601 CENTRAL AVE NE
+
501 CENTRAL AVE NE
RESPONSE TO SKETCH PLAT
COMMENTS

Integrated Design & Architecture
Meeting Date: March 20, 2024

USABLE OPEN SPACE - GROUND FLOOR & SITE

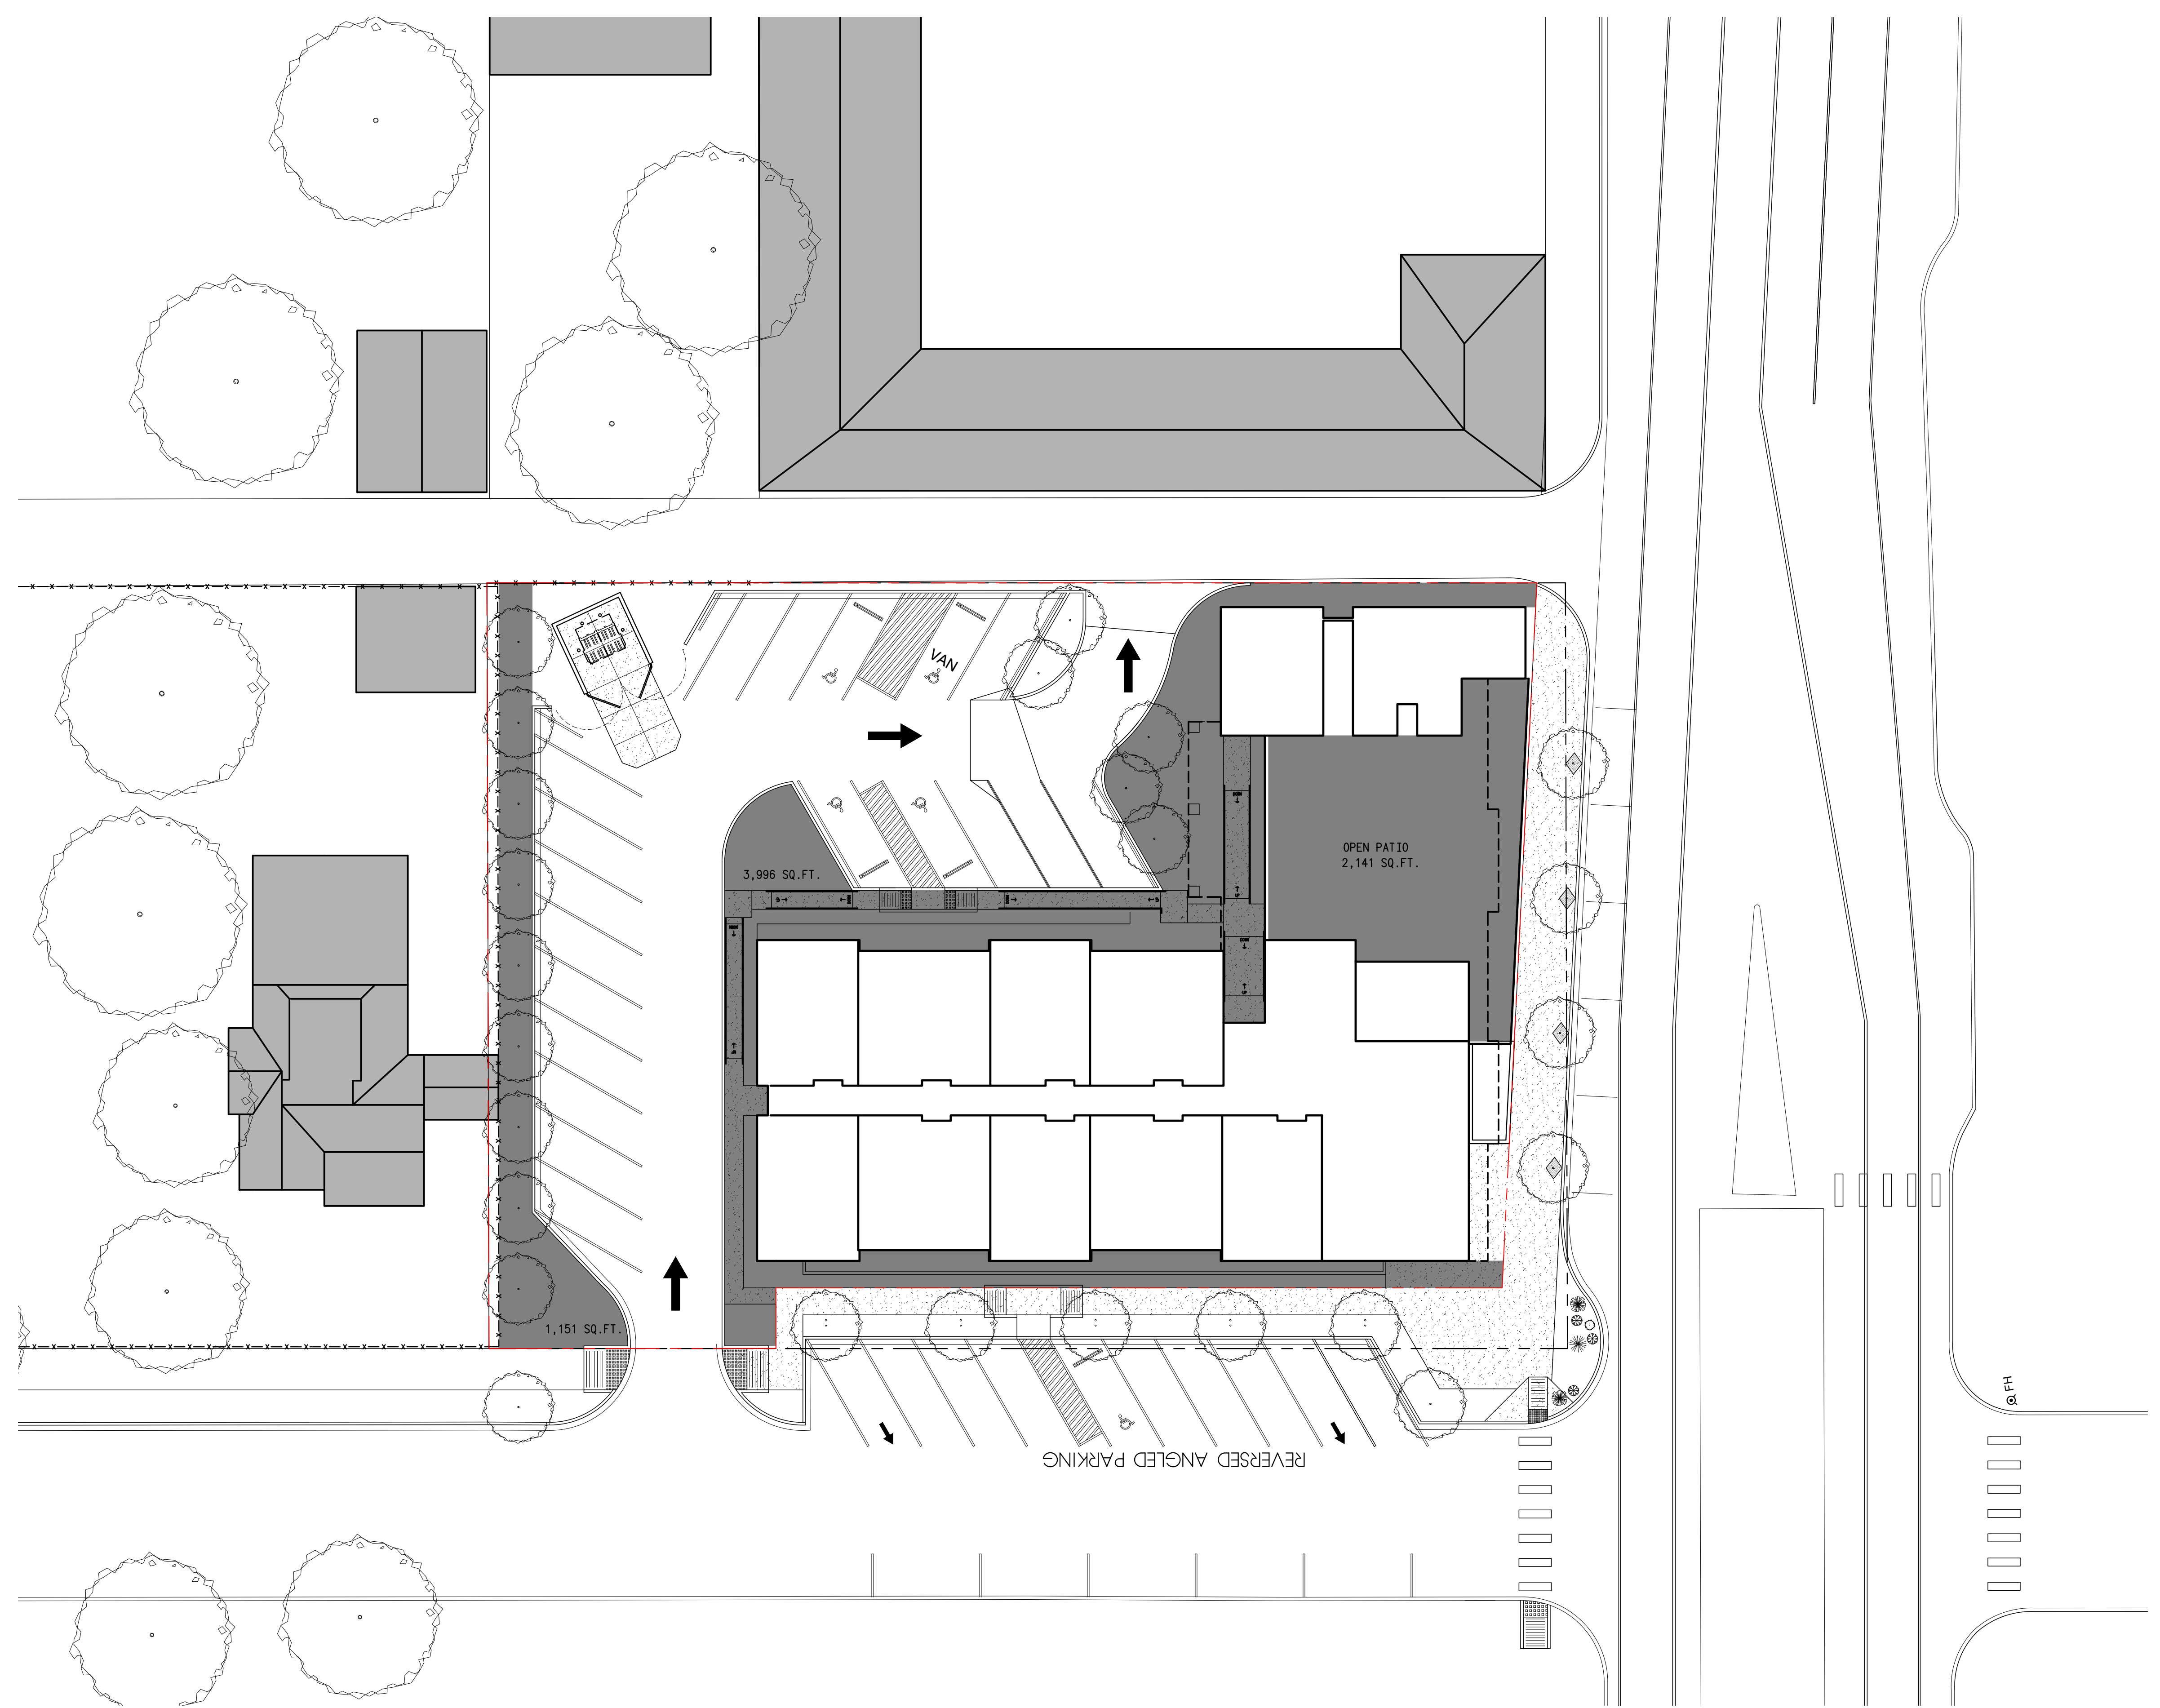
$68 \times 225 = 15,300$ sq.ft.

$15,300 / 2 = 7,650$ sq.ft.

Site: 5,147 sq.ft.

Covered Patio: 2,141 sq.ft.

Rooftop: 0 sq.ft. (362 sq.ft. needed (2,505 sq.ft. available))

Total: 7,288 sq.ft.

Variance Needed = 362 sq.ft. (5 sq.ft. / unit)
